***Student Accommodation on Blocks 3B, 3C &
Block 10***

***Central Park, Chippendale (Former Carlton
United Brewery)
MP11_0090***

Director General's
Environmental Assessment Report
Section 75I of the
Environmental Planning and Assessment Act 1979

November 2012

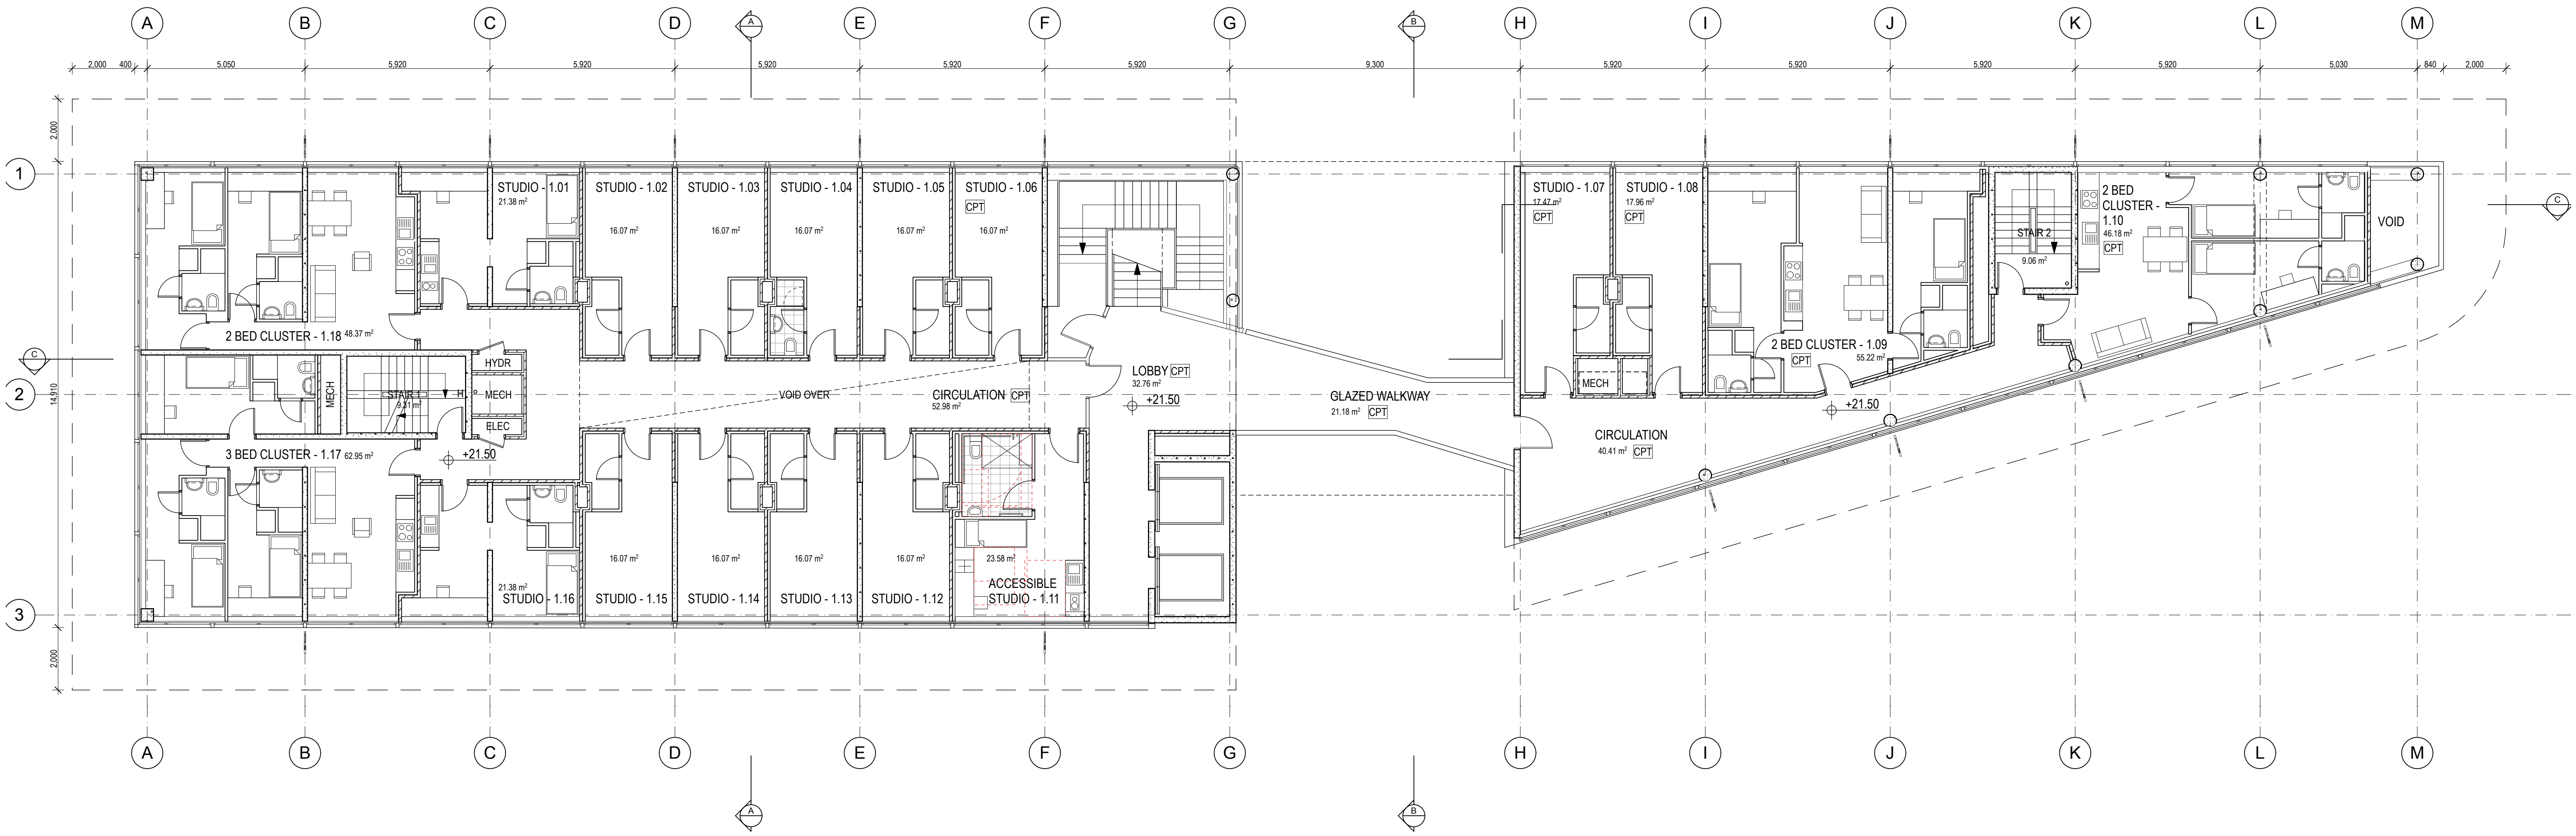
- concern raised in regard to height of the lowest level of the proposed pedestrian link between Buildings 3B and 3C;
 - concerns regarding inactivation of ground floor level of Block 3B to Carlton Street;

The EA proposed a link between the buildings on Blocks 3B and 3C on the first level, with a height of 3.75 metres above ground level. The PPR has, however, resulted in the deletion of the link at first floor level, as a response to concerns raised by the Department relating to impacts on the identified through link and general streetscape appearance.

- the proposed fixed louvres were replaced with internal blinds;
- level 1 of the Link Bridge was removed to comply with the Concept Plan;
- removal of perpendicular signage to allow the ground level façade to be easily read; and
- the ground façade of Blocks 3B and 3C have been revised to include blue/black brickwork paving to the ground plan and lift shaft, assembled in a herringbone pattern.

The amended pedestrian link between Blocks 3B and 3C will have a minimum height of 6.44 metres above ground level. The amended envelope of the pedestrian link is consistent with the approved Concept Plan building envelope and will result in an improved appearance of the bridge compared to the EA proposal. The additional height will emphasise the break between the two buildings and result in a more attractive through passage between the eastern and western parts of the Central Park development.
